Sent: 14 October 2014 15:32
To: Planning.Responses
Cc: Ann Rapnik
Subject: RE: Planning Consultation on: BE/114/14/PL

**WEST SUSSEX COUNTY COUNCIL
STRATEGIC PLANNING CONSULTATION**

SUBJECT: BE/114/14/PL - Demolition of single storey side extension and attached double garage and erection of a pair of 3 bedroomed semi-detached houses. Resubmission of BE/57/14

346, Chichester Road, North Bersted, Bognor Regis, West Sussex, PO21 5BX

CYCLE STORES

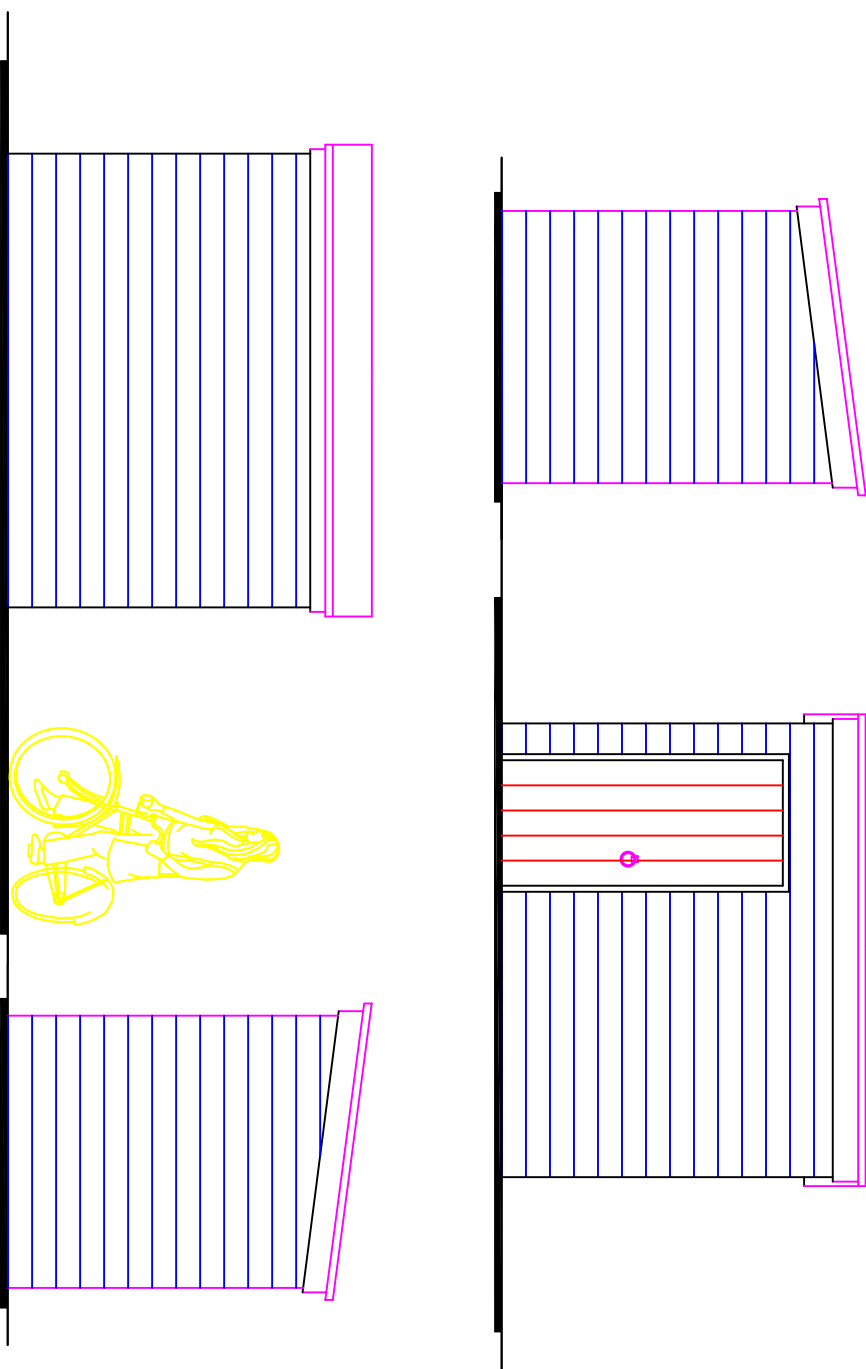
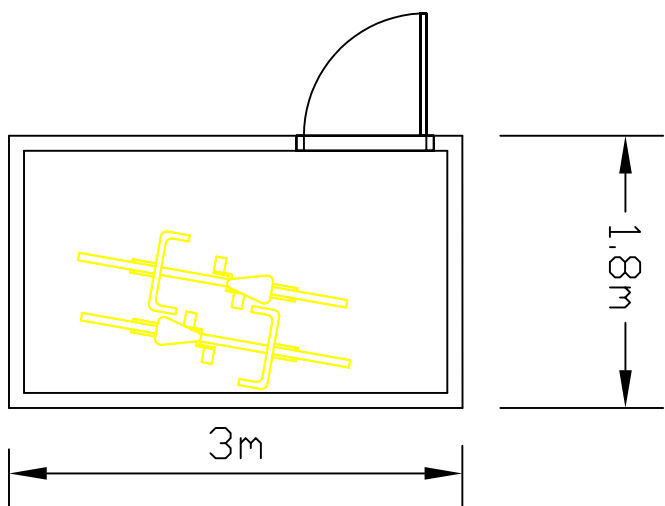
An appropriate level of cycle parking has also been demonstrated, this provision can be secured in perpetuity via condition.

Title
Proposed Ground Floor Plans

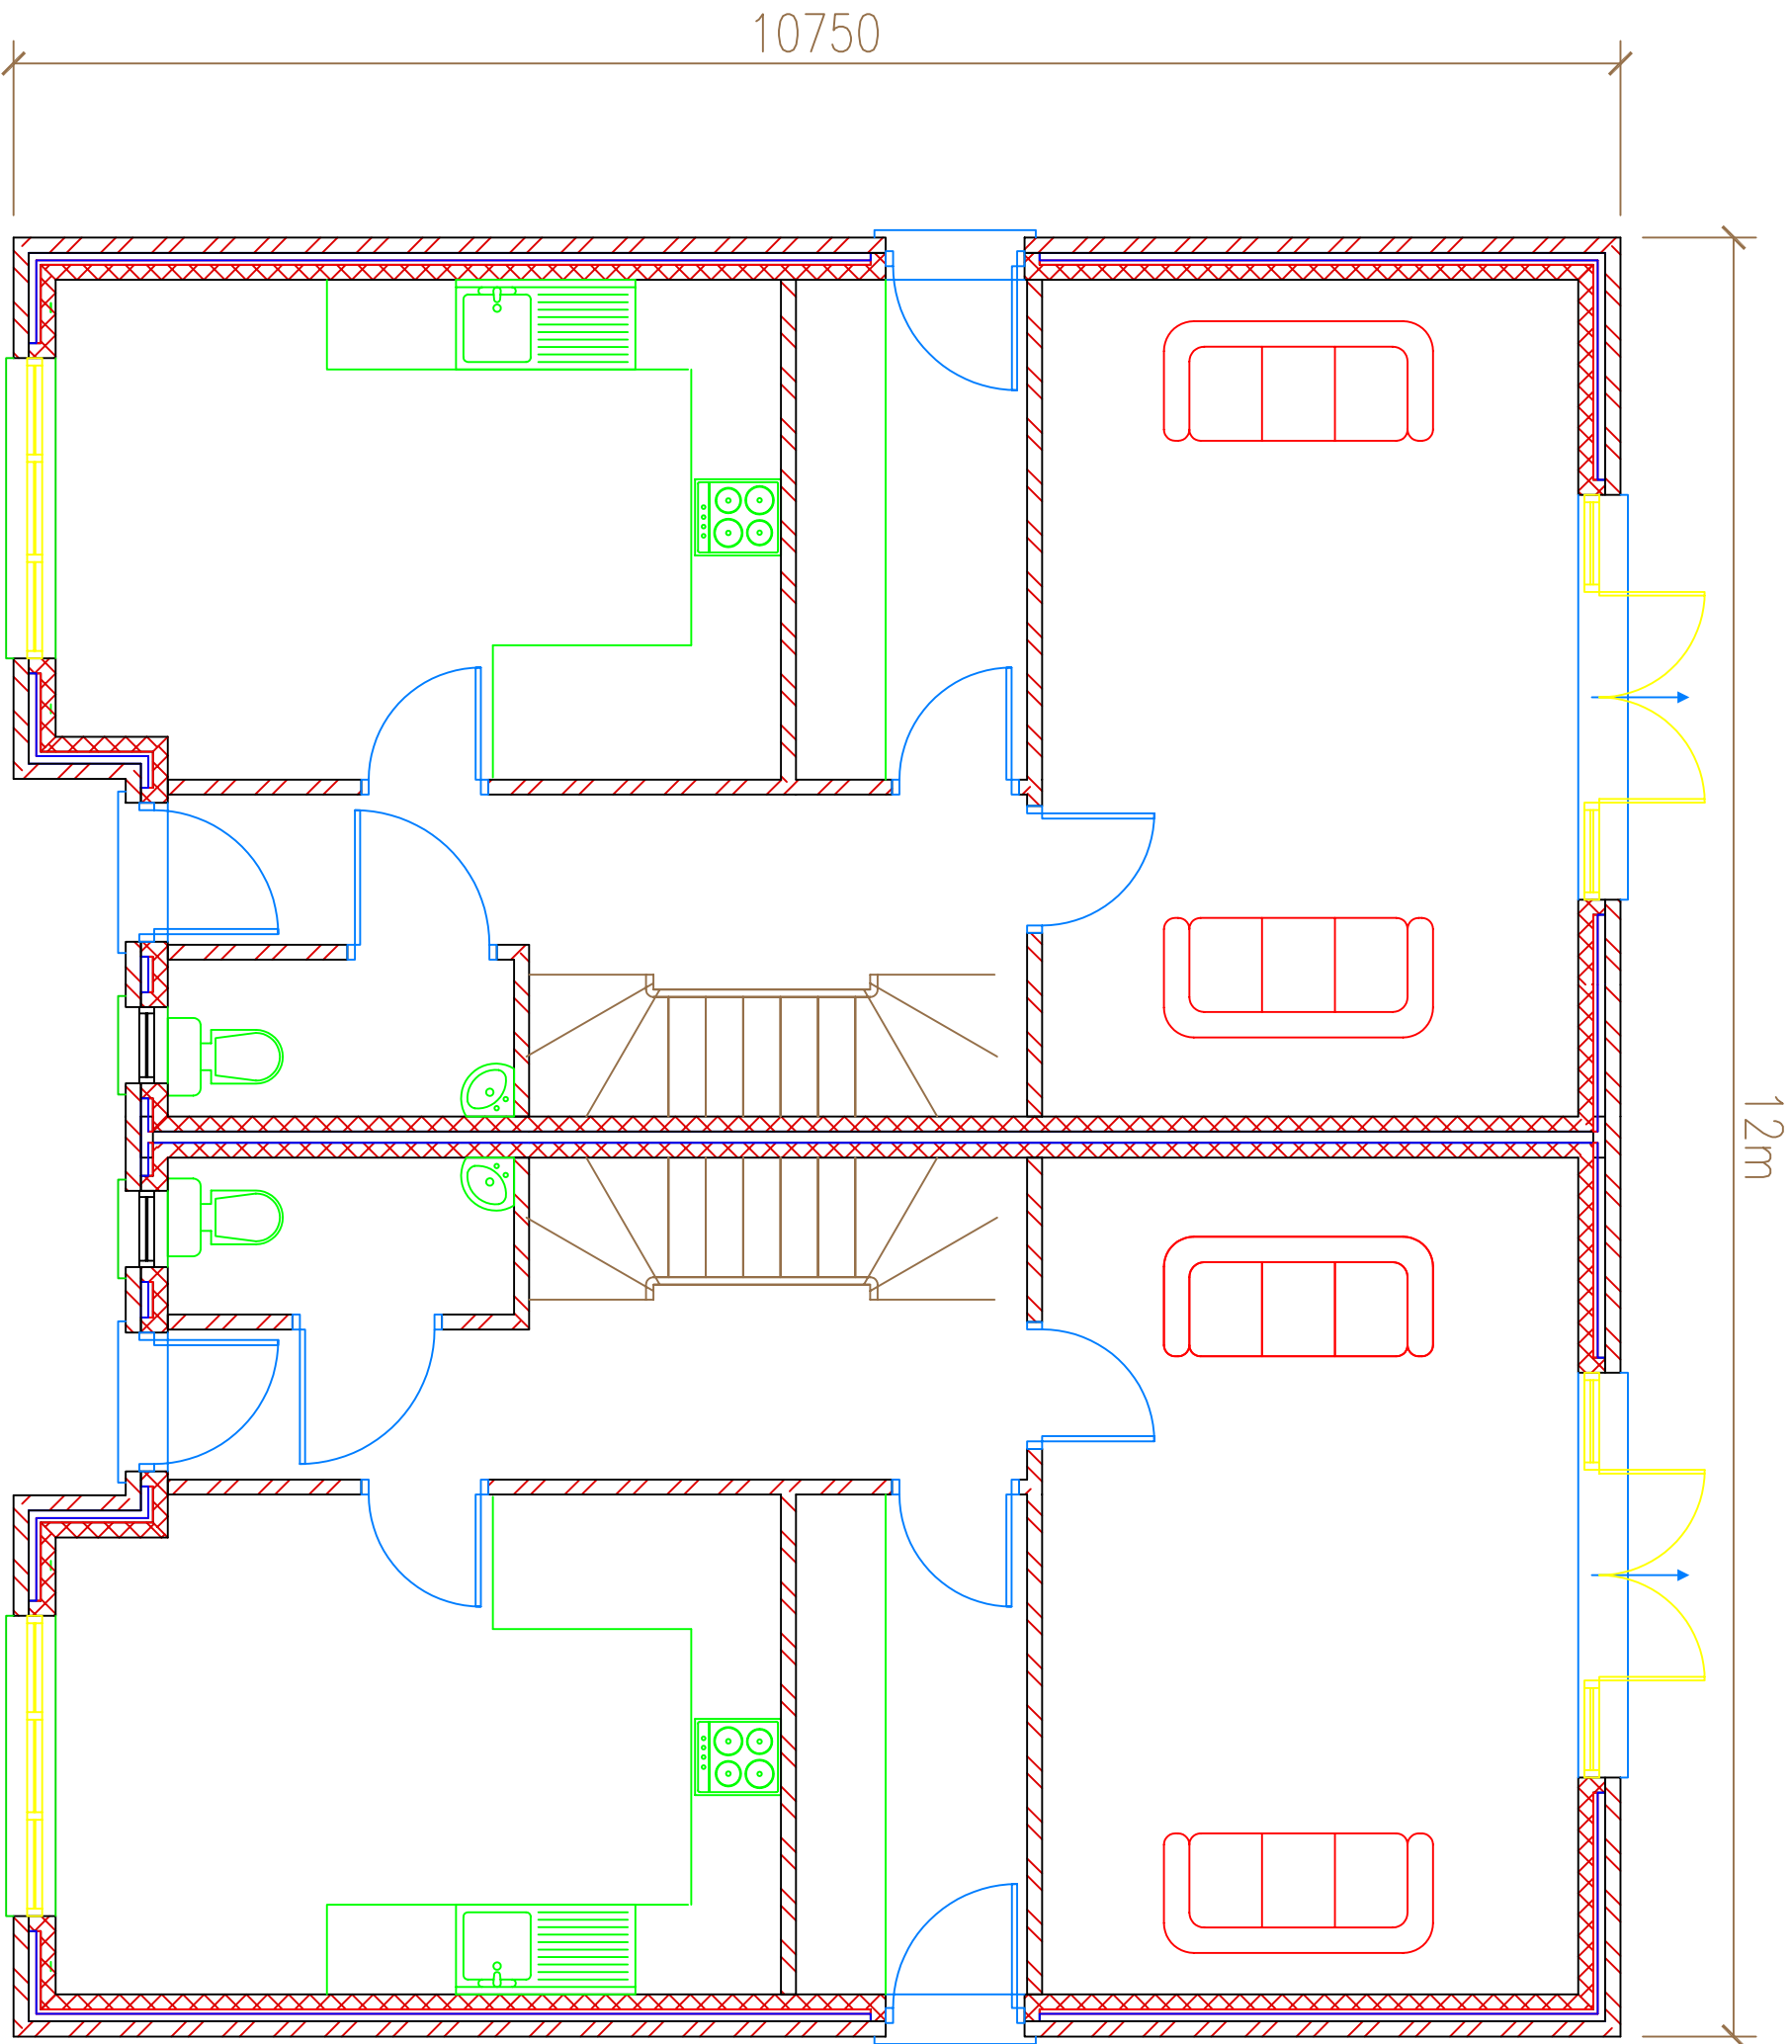
The proposed parking layout demonstrates 4 appropriately sized parking spaces with each parked vehicle afforded an appropriate amount of manoeuvring room so that a multi-point manoeuvre could be achieved to enter and exit the site in the forward gear.

2 x 2 metre pedestrian visibility splays have also been demonstrated at the site access. These splays can be maintained in perpetuity via condition.
